From: Contact Centre (CRM) <contact@ribblevalley.gov.uk>
Sent: 24 March 2026 12:37
To: Planning
Subject: Planning Application Comments - 3/2026/0021 FS-Case-817244874

Planning Application Reference No.: 3/2026/0021

Address of Development: Flat, 41-43 Wellgate Clitheroe BB7 1LU

Site Plan

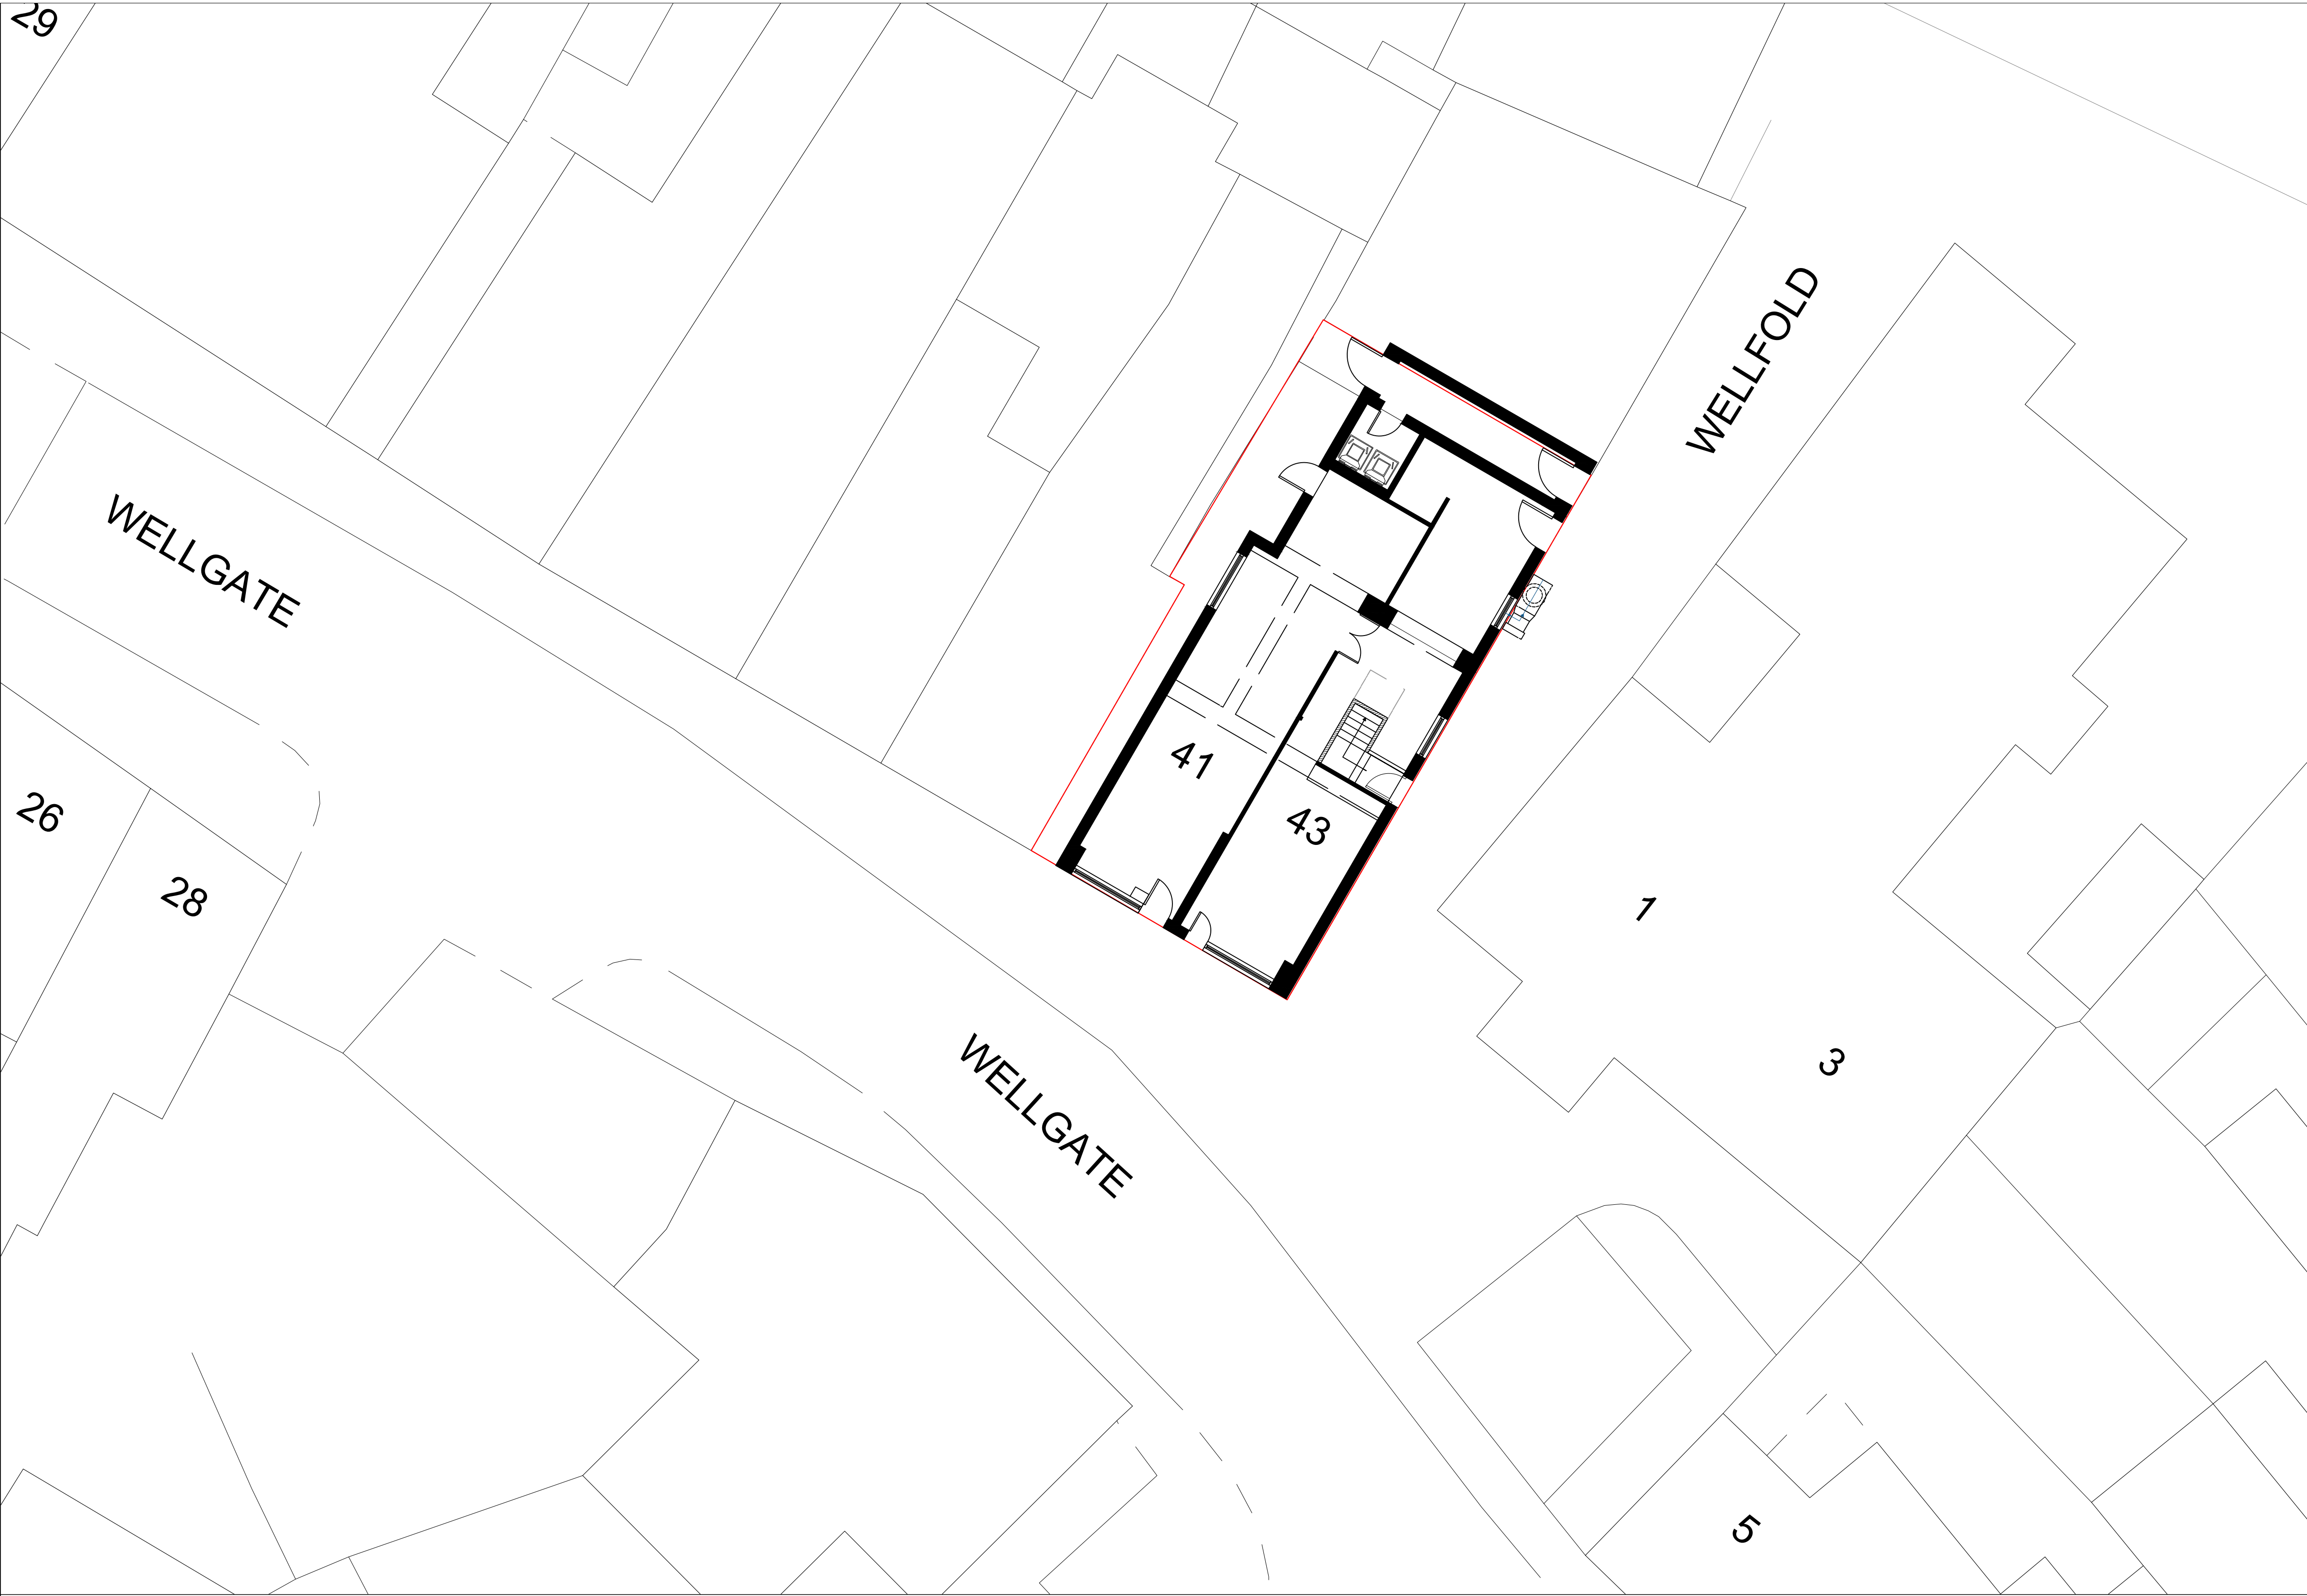
Point 1 is the boundary that is marked on the location plan in red is inaccurate as it is impinges onto our [REDACTED] in fact the outside wall of no 41 Wellgate.
